**189 KINGSWAY BN3 4FB
MINOR NON MATERIAL AMENDMENTS TO BH2020/03522**

This letter is submitted in respect of the above application for minor non material amendments to the floor plans approved as part of planning permission BH2020/03522.

Originator JMG/LW	Approved MK	Date 17.09.2019	Scale 1:200 @ A1
Drawing No. 5471-036	Rev. D	Sheet No. 1/1

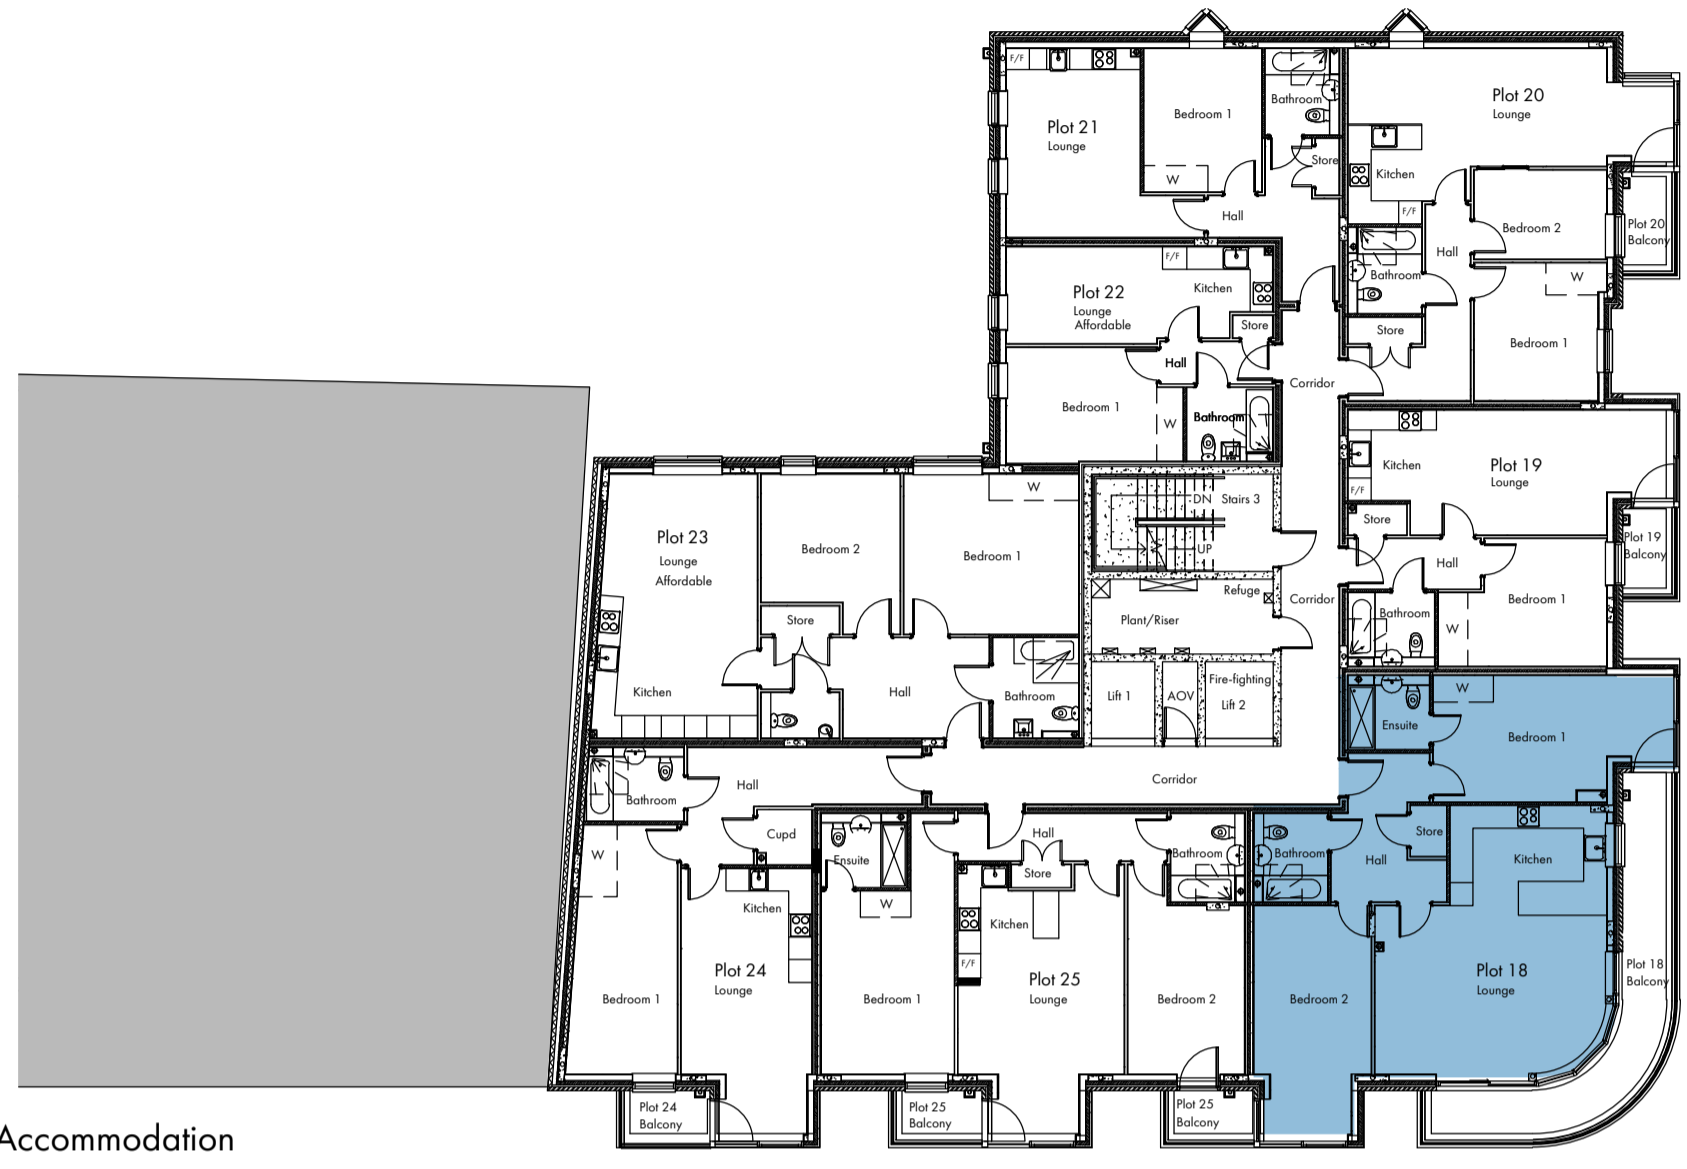
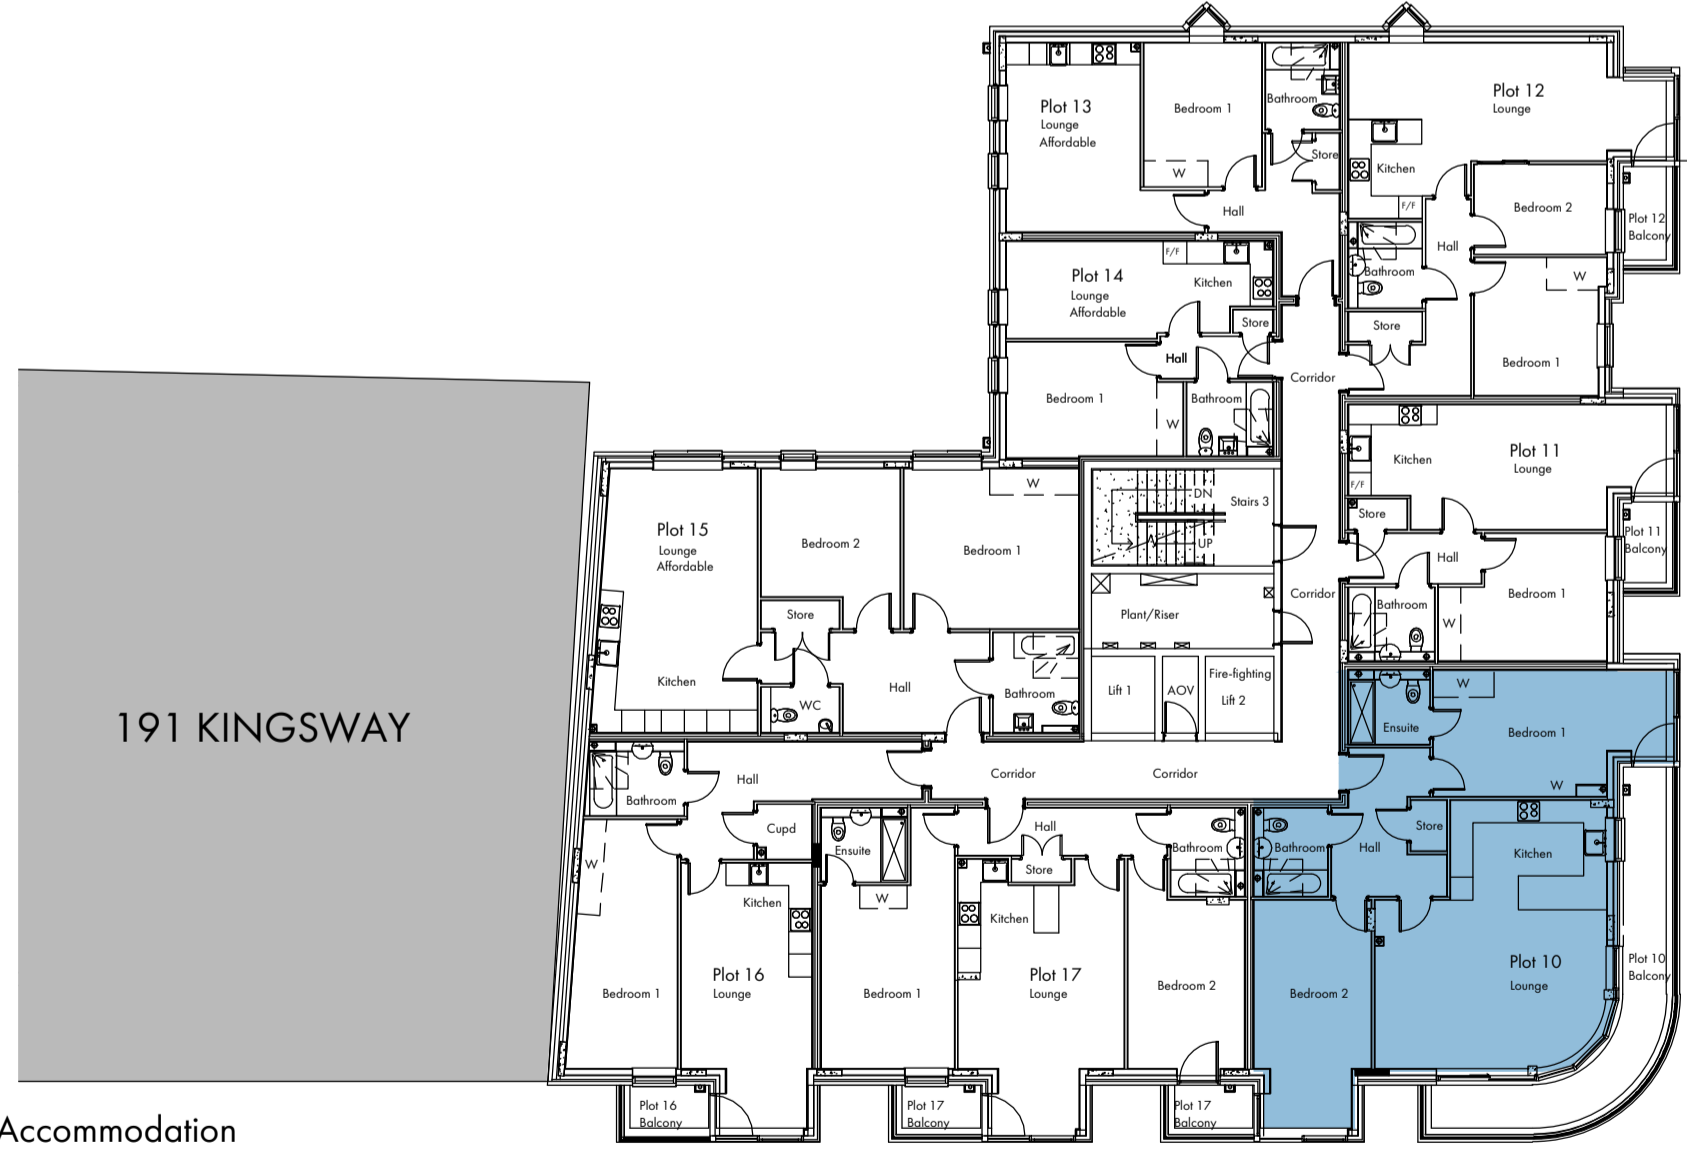
Each of the south east corner units is to change from a 3 bedroom unit to a 2 bedroom unit.

FIFTH FLOOR PLAN - With amendment

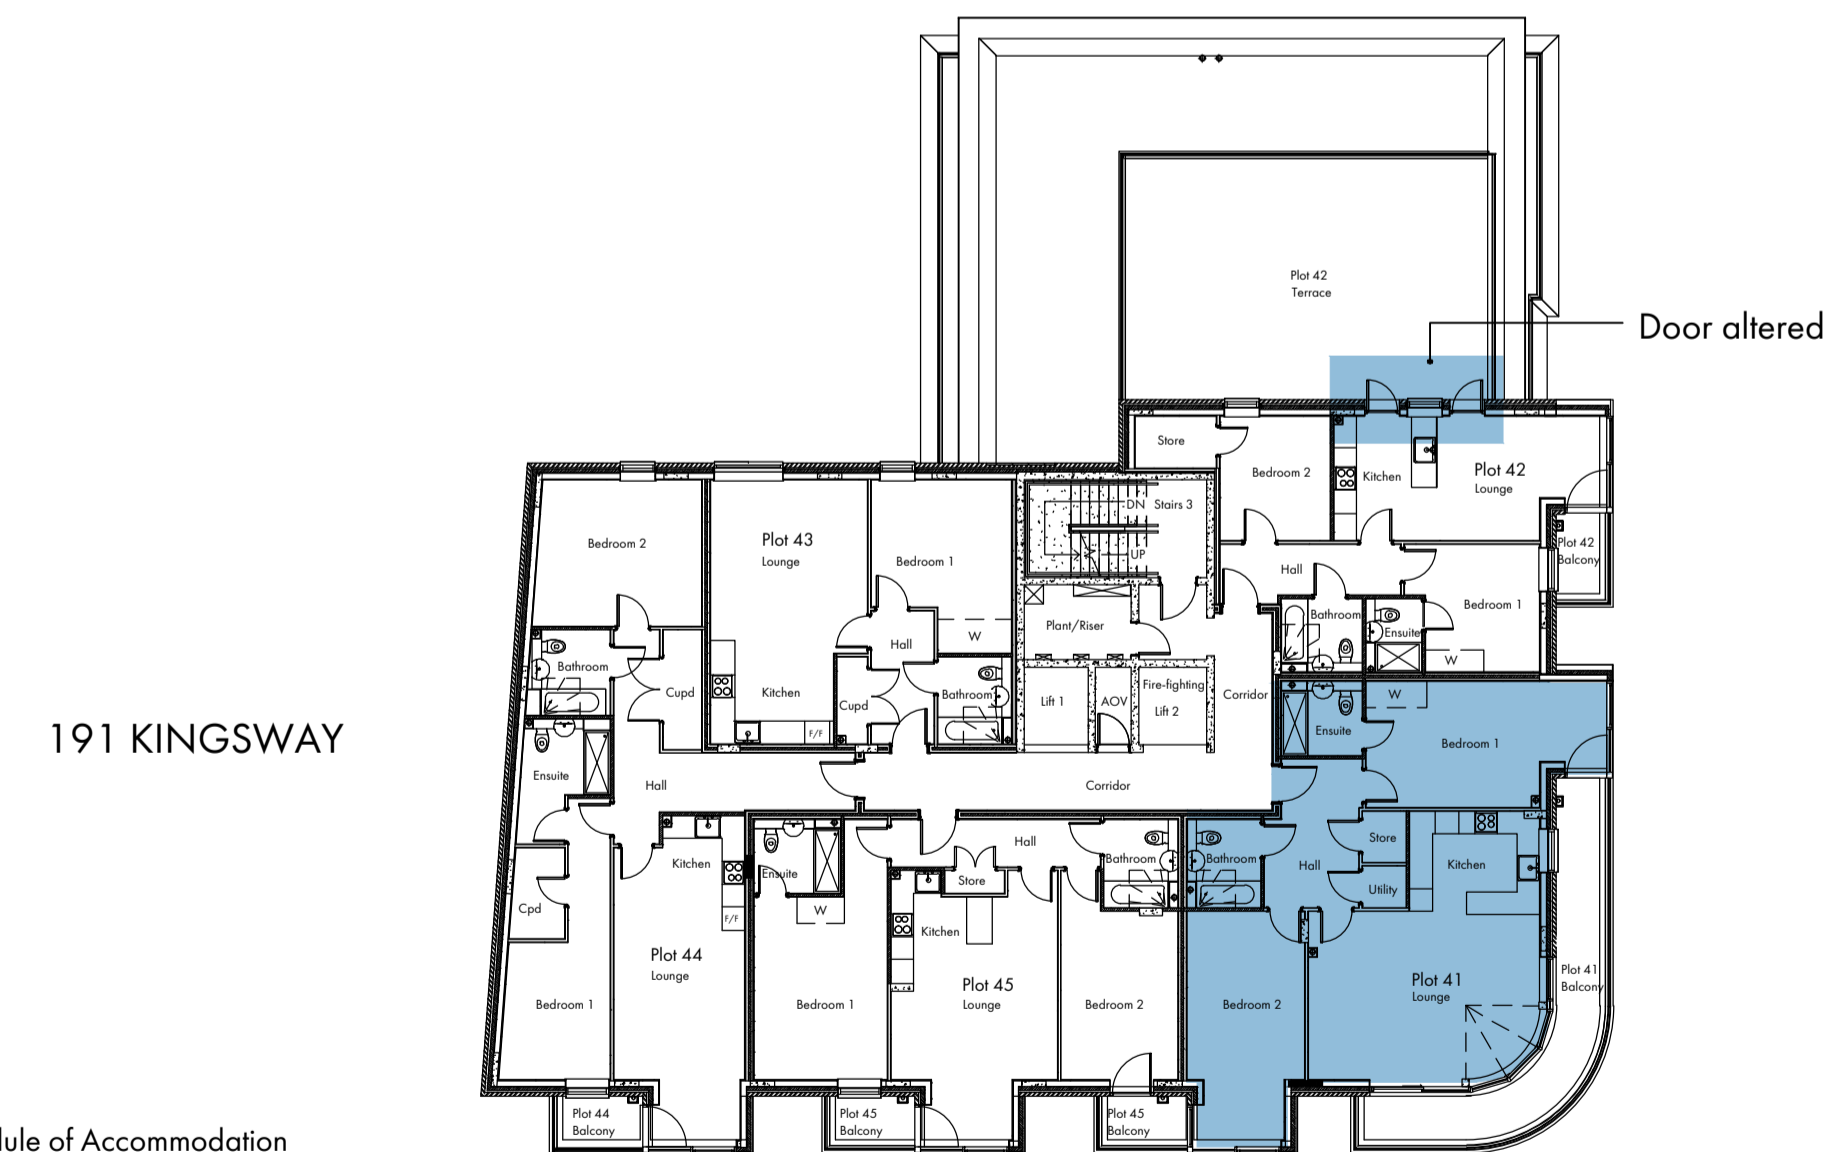
Alterations to Access Door to Plot 42

Access from plot 42 to its roof terrace is to be changed from a pair of sliding doors, to a pair of casement doors either side of a central window – see plans overleaf. Given the depth of plot 42’s terrace, this alteration will not be visible and is *de minimis*.

FOURTH FLOOR PLAN - With amendment

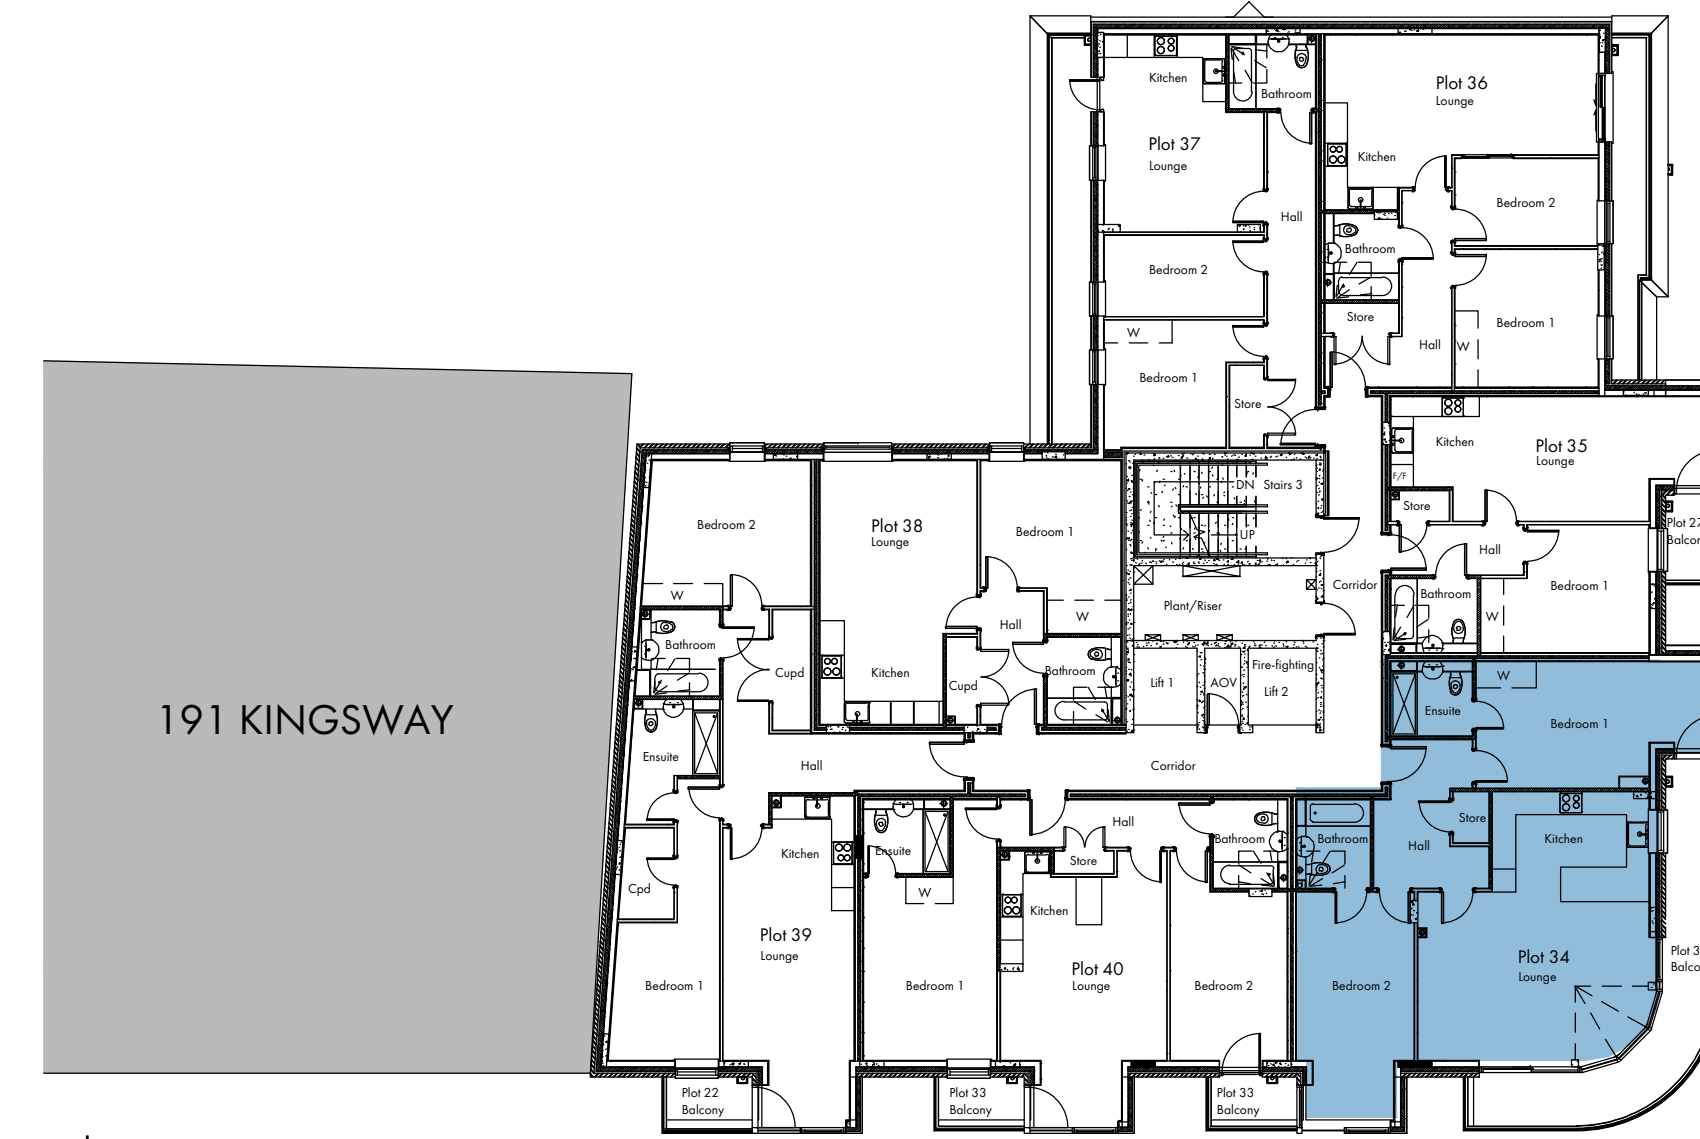
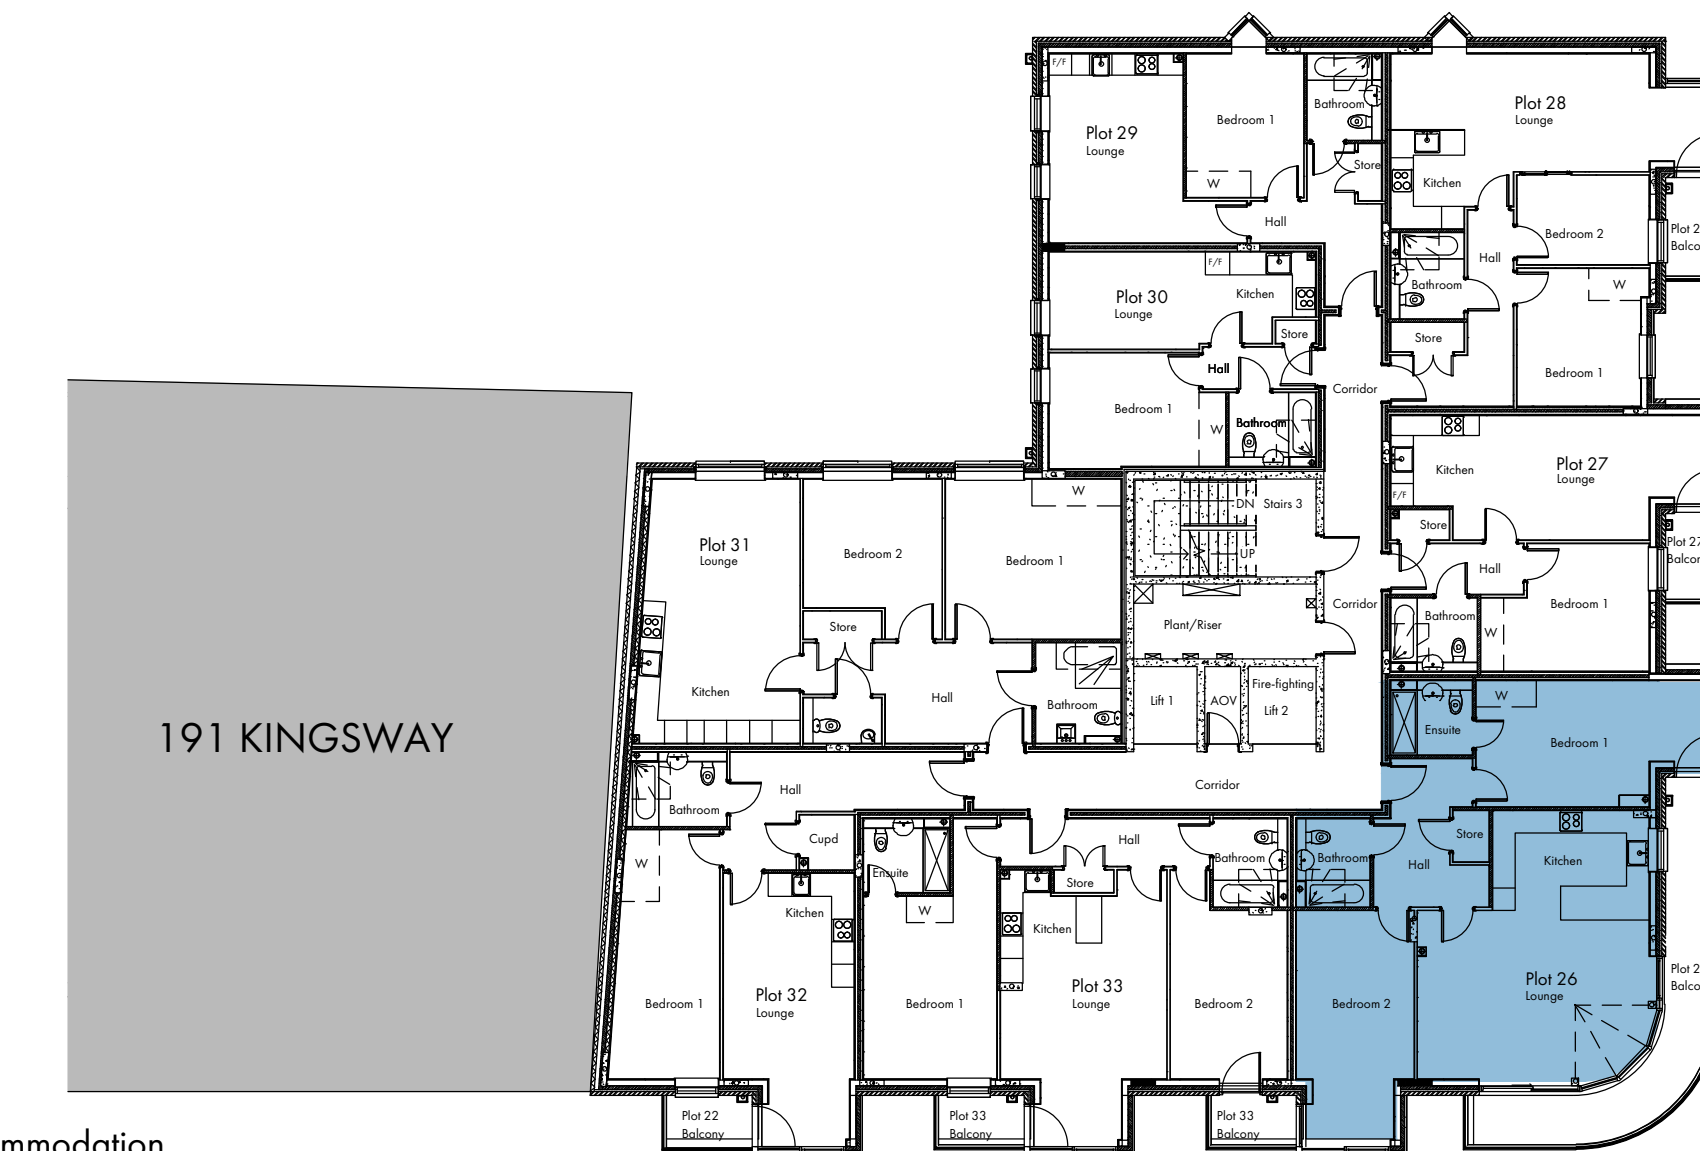
Conversion of 3 bed units to 2 bedroom units

Typical approved and proposed floor plans (showing the 4th floor) are shown below:
